## Supplemental Instruction

**The Park Danforth**

13-059-00

**DRAWING CLARIFICATIONS FROM AHJ REVIEW**

D7 ROOF EDGE DETAIL AT OVERHANG W/ BEAM
A3.10 3" = 1'-0"

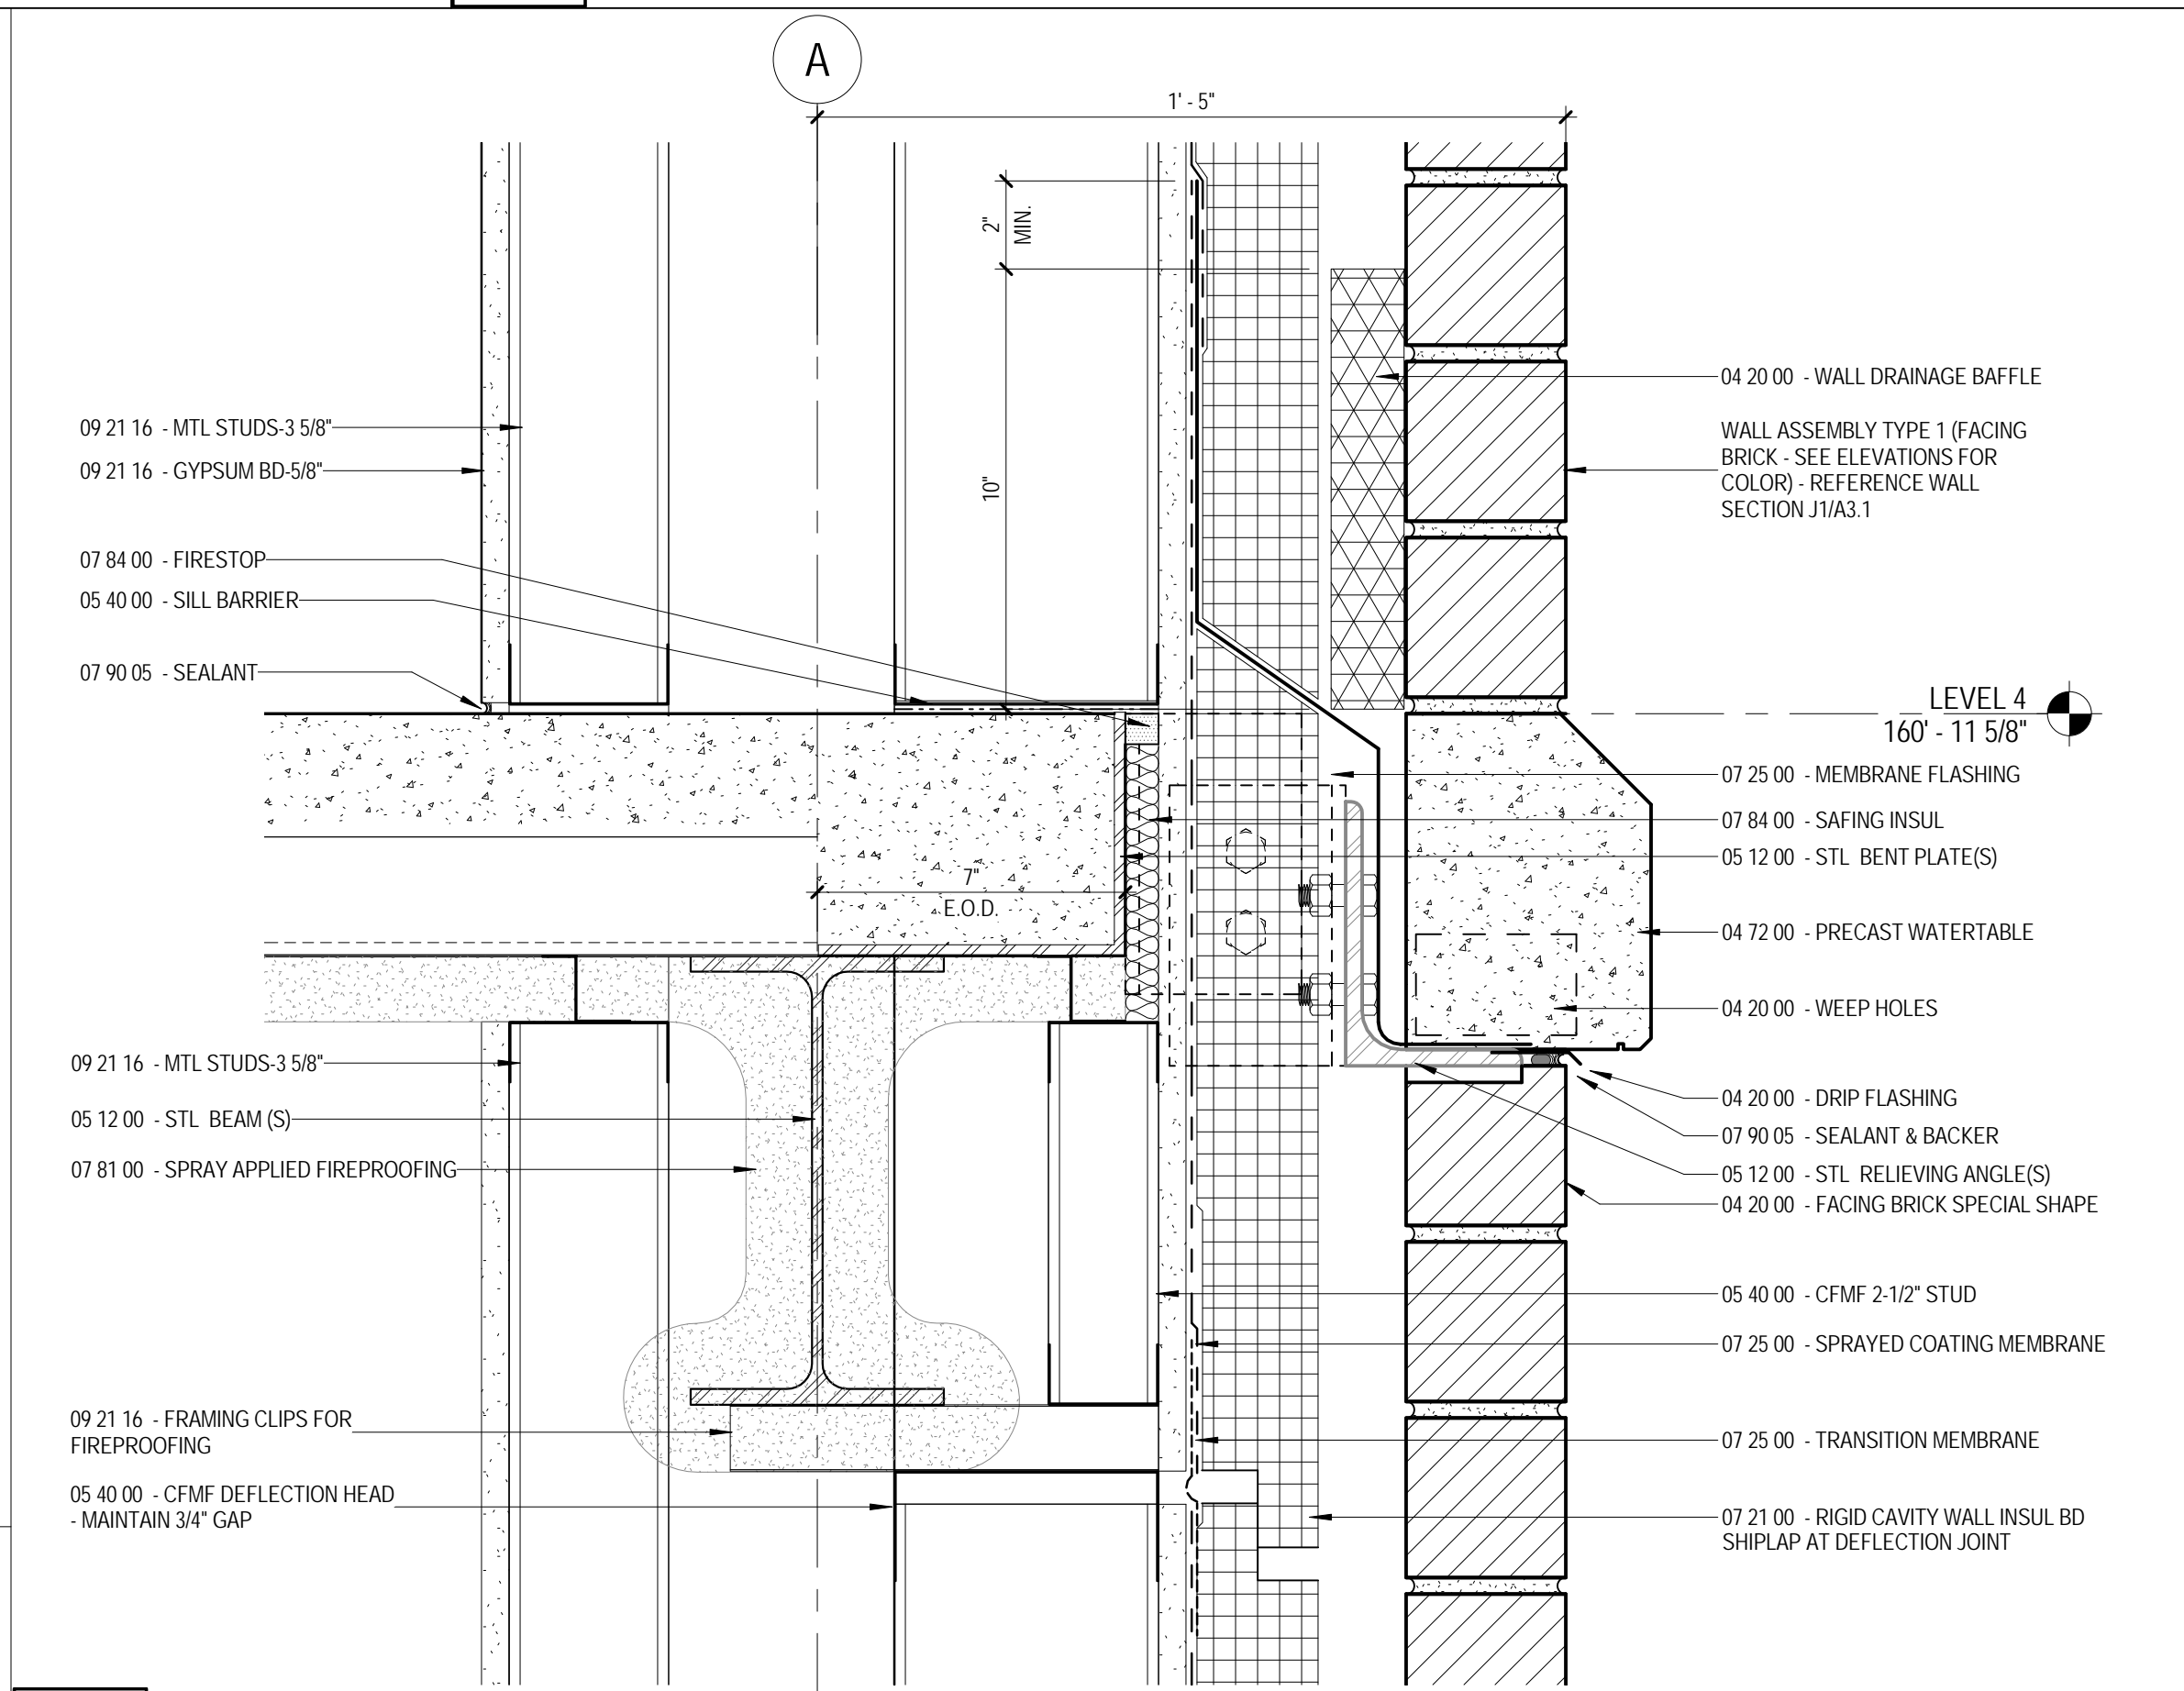
1. Reference Wall Section D7/A3.6: Delete the following: "REFERENCE WALL SECTION D12/A3.6", from the Roof Assembly Type 3 note.
2. Reference Section E6/A3.16 - Section Detail @ Firewall: See attached sketch for clarifications.
